DECISION DELEGATED TO HEAD OF PLANNING

Application No:	H13-0270-25	Applicant:	Florinee Homes Ltd
Proposal:	Change of use from residential dwelling to children's home. Approved under H13-0524-24. Modification of Condition 2 to allow amendments to previously approved plans & Condition 5 relating to car parking management plan		
Location:	29 Pipwell Gate Moulton Seas End Spalding		
Terminal Date:	14th May 2025

Scale: 1:100 @ A3 Date: 23/05/24  
Drawing Title: PROPOSED FLOOR PLANS  
Drawing No. 575SK02 Revision C  
ALL DRAWINGS ARE THE COPYRIGHT OF I-100 DESIGN

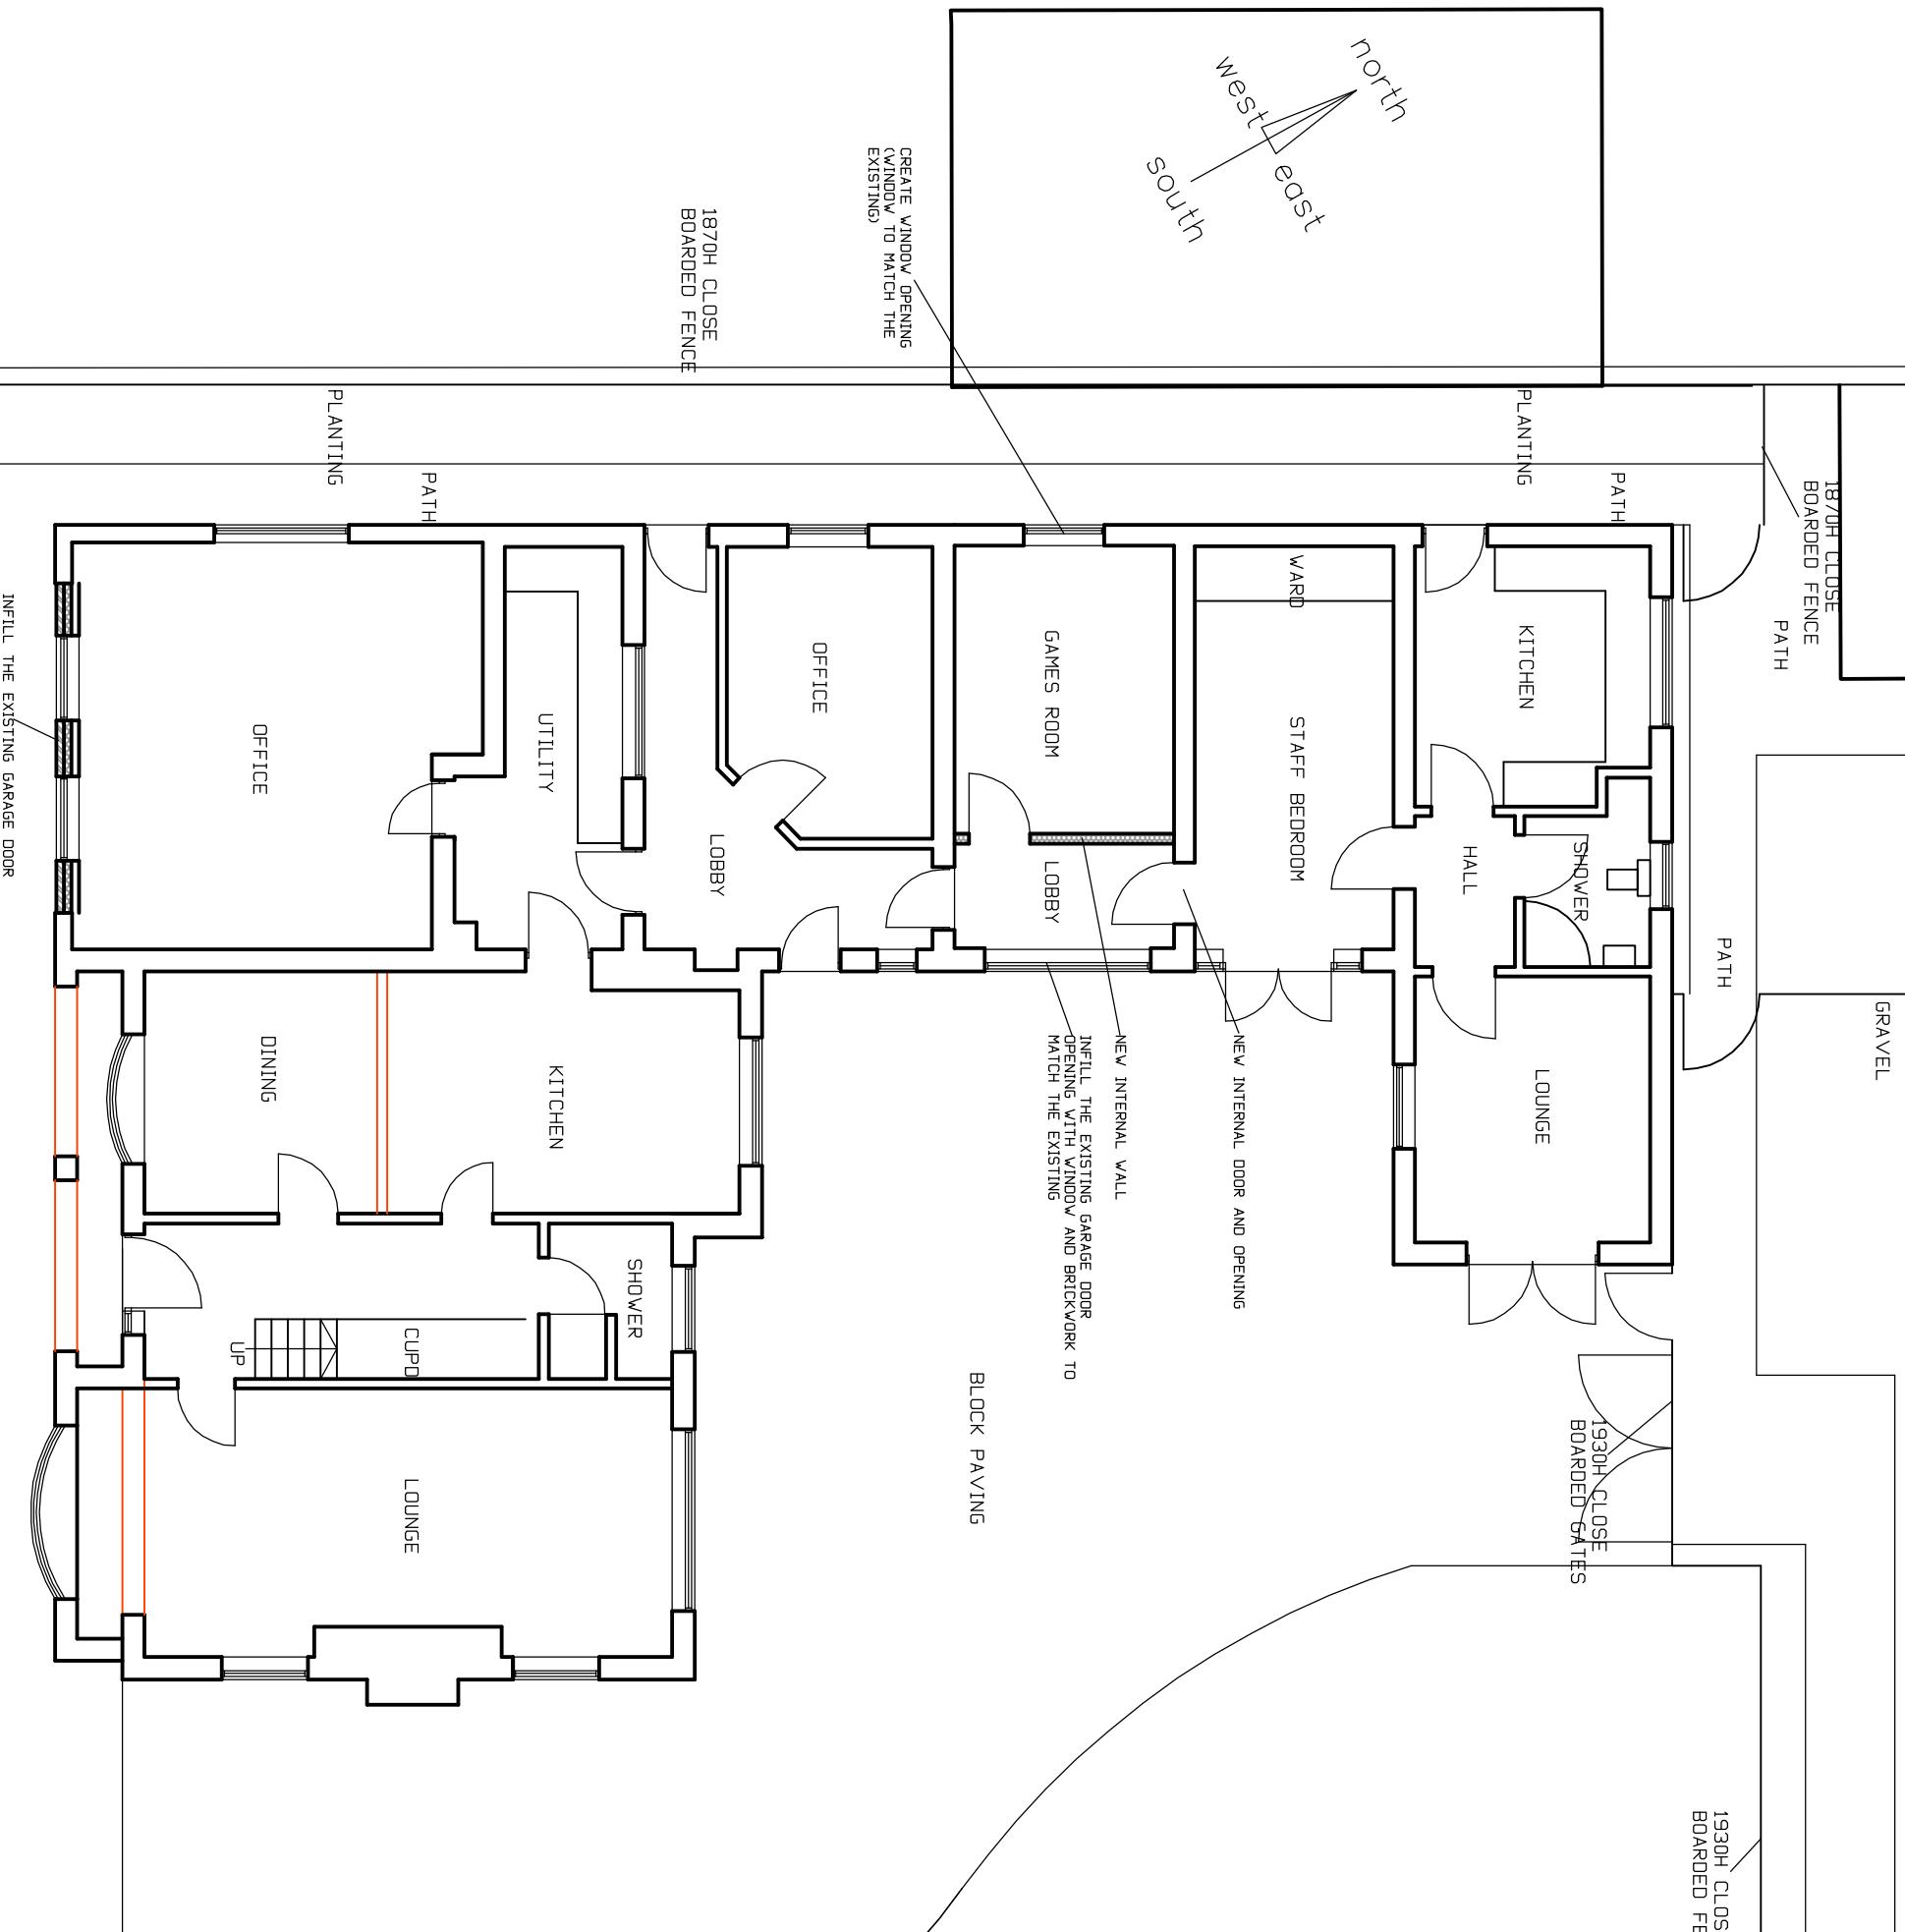
Within the public representation that has been received during the determination of the application, concerns have been raised due to the proposed games room that would be connected to this window. Concerns have been raised due to the potential noise disturbance that could arise in this room. It is however not considered that this room would generate significant levels of noise.

It was previously considered the proposed occupation of the site by four children, living as if in a supported family with relevant staff members, would not result in adverse levels of noise. It is likely that the noise levels generated from the games room as part of the wider care home would not be materially different than those generated from a typical dwelling. Furthermore, if the site remained as a dwelling, the room could be turned into a games room without planning permission and children within the dwelling could use the room for a similar purpose.

Drawing No.: 575SK03 Revision: C

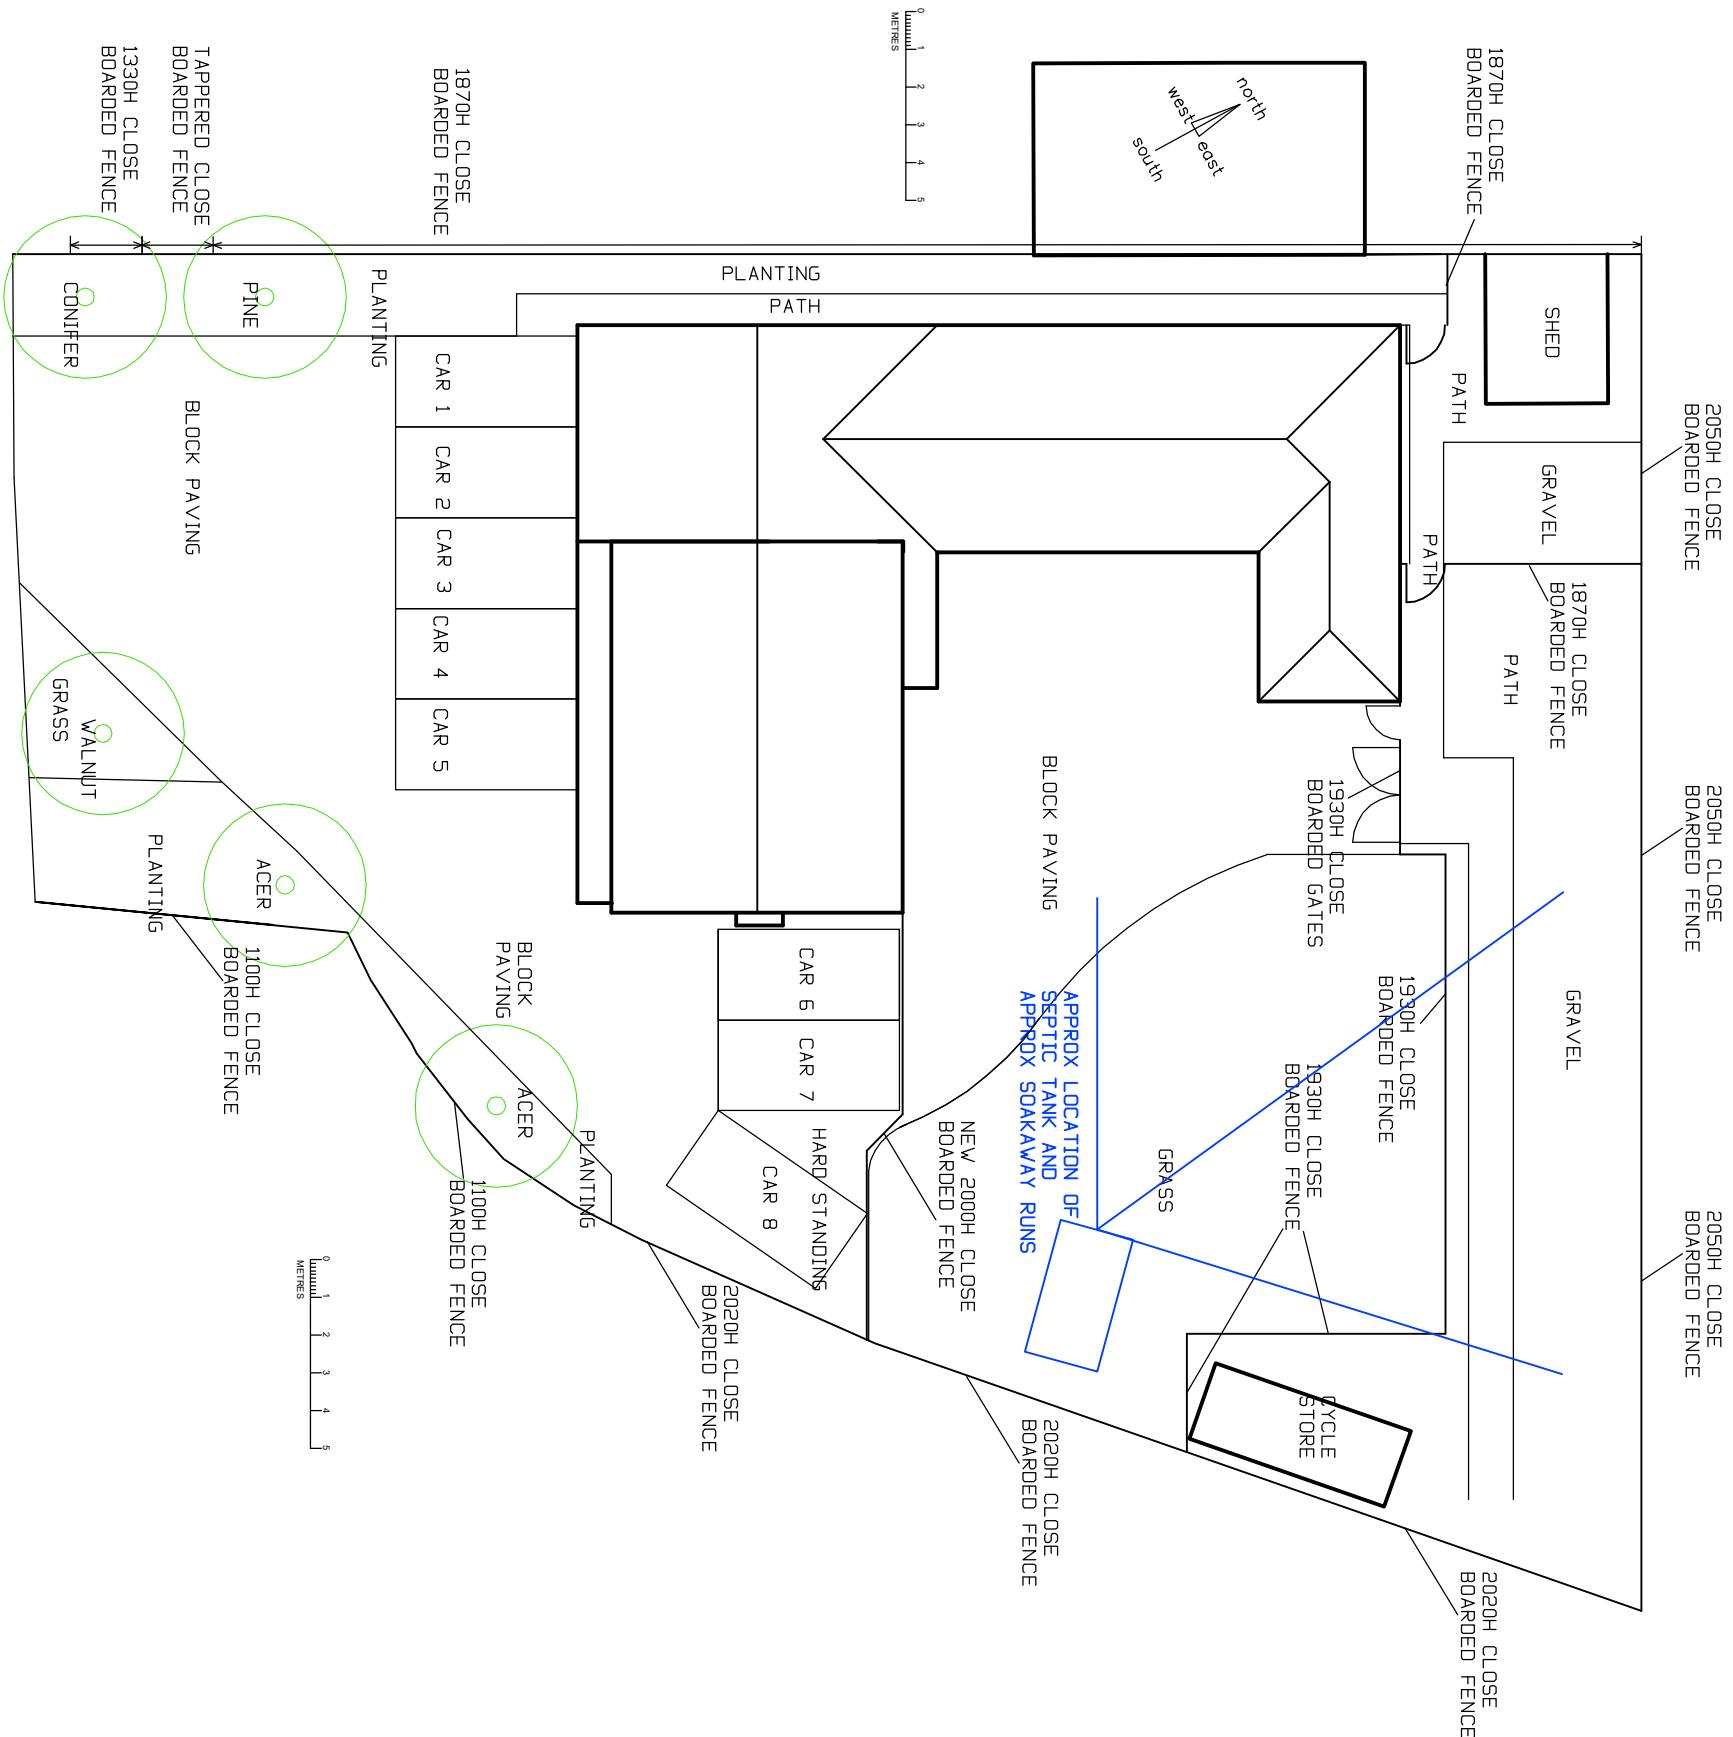
Previously, two integrated garages were proposed, whereas under the proposed plans, no integrated garages would be provided. All parking would therefore be external. One of the external planting areas is proposed to be replaced with paving to allow for the reconfiguration of the parking spaces. A 2.25m high brick wall was previously proposed to be retained next to the south-eastern elevation of the building within the site. This wall is now proposed to be removed and a 2m high close boarded fence is proposed instead which would be located approximately 7.7m to the north of the existing wall. The visual impact of this fence is considered to be acceptable and furthermore, the fence could be installed using permitted development rights.

Lincolnshire County Council's (LCC) highways team have reviewed the proposals and have confirmed that the proposed amended layout is acceptable. This includes the revised parking arrangements. Eight parking spaces would be provided for the proposed development. Previously eight external spaces were proposed and some internal parking would have been provided within one of the integrated garages. It was previously accepted during the determination of the original application that five staff members will be present during the day, and a tutor might also be present. It is therefore likely that a maximum of 6 parking spaces would be required. As such, sufficient off-street parking is proposed. The proposed alterations to the site layout are therefore also acceptable and are considered to accord with the aims of Policy 36 of the Local Plan.

As set out above, LCC's highways team have set out that the proposed amended layout is acceptable. The amended layout shows eight parking spaces and there is therefore room for parking and turning within the site. As such, it is considered appropriate to remove condition 5 as the condition is no longer considered to be necessary.

Drawing Title: PROPOSED ELEVATIONS

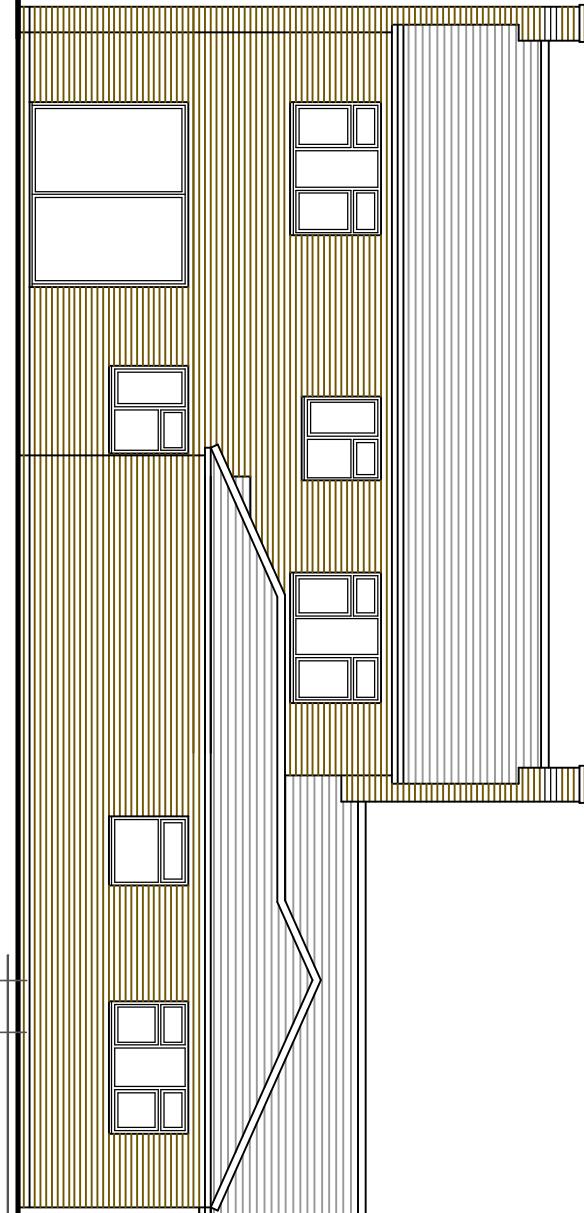
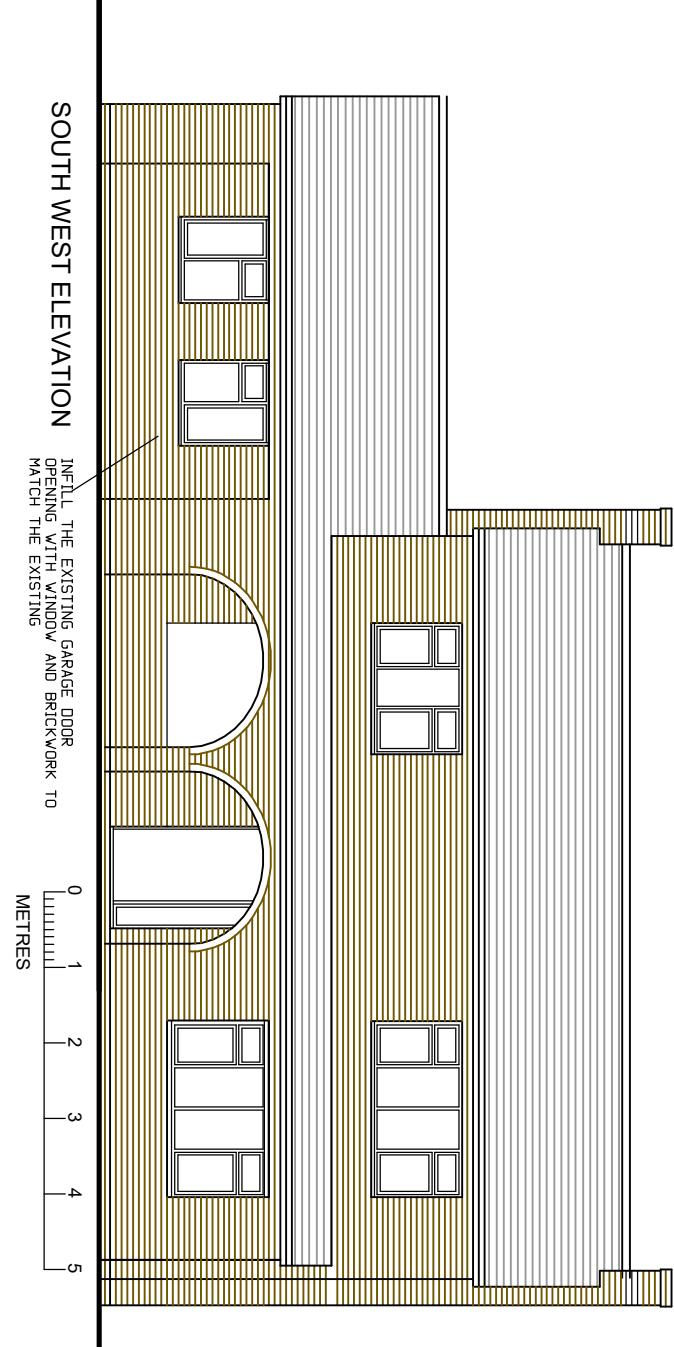
The visual impact of the proposed replacement of the garage doors with windows is considered to be acceptable. The submitted elevations plan sets out that the proposed infill brickwork would match the existing brickwork as closely as possible. It is considered appropriate to include a condition requiring the brickwork and mortar to match the existing brickwork for clarity and in the interests of visual amenity.

In terms of the amenity impact of the proposed windows, the proposed windows on the front elevation (south-eastern elevation) would not look directly onto the habitable rooms of neighbouring properties. The proposed window on the north-western elevation would face onto a 1.87m close board fence which separates the site from 27 Pipwell Gate. This should therefore not result in an unacceptable degree of overlooking with the neighbouring dwelling.

There is also considered to be a suitable separation distance between the proposed window on the south-eastern elevation and the nearest dwelling to the south-east, 31 Pipwell Gate. This window would not face directly onto any habitable rooms of 31 Pipwell Gate and there is a 2m high fence between the dwellings to provide screening. As such, the proposed amendments should not result in an unacceptable degree of overlooking.

As set out previously, is it considered appropriate to add a condition requiring the proposed infill brickwork to match the existing brickwork as closely as possible. This condition is now condition 5.
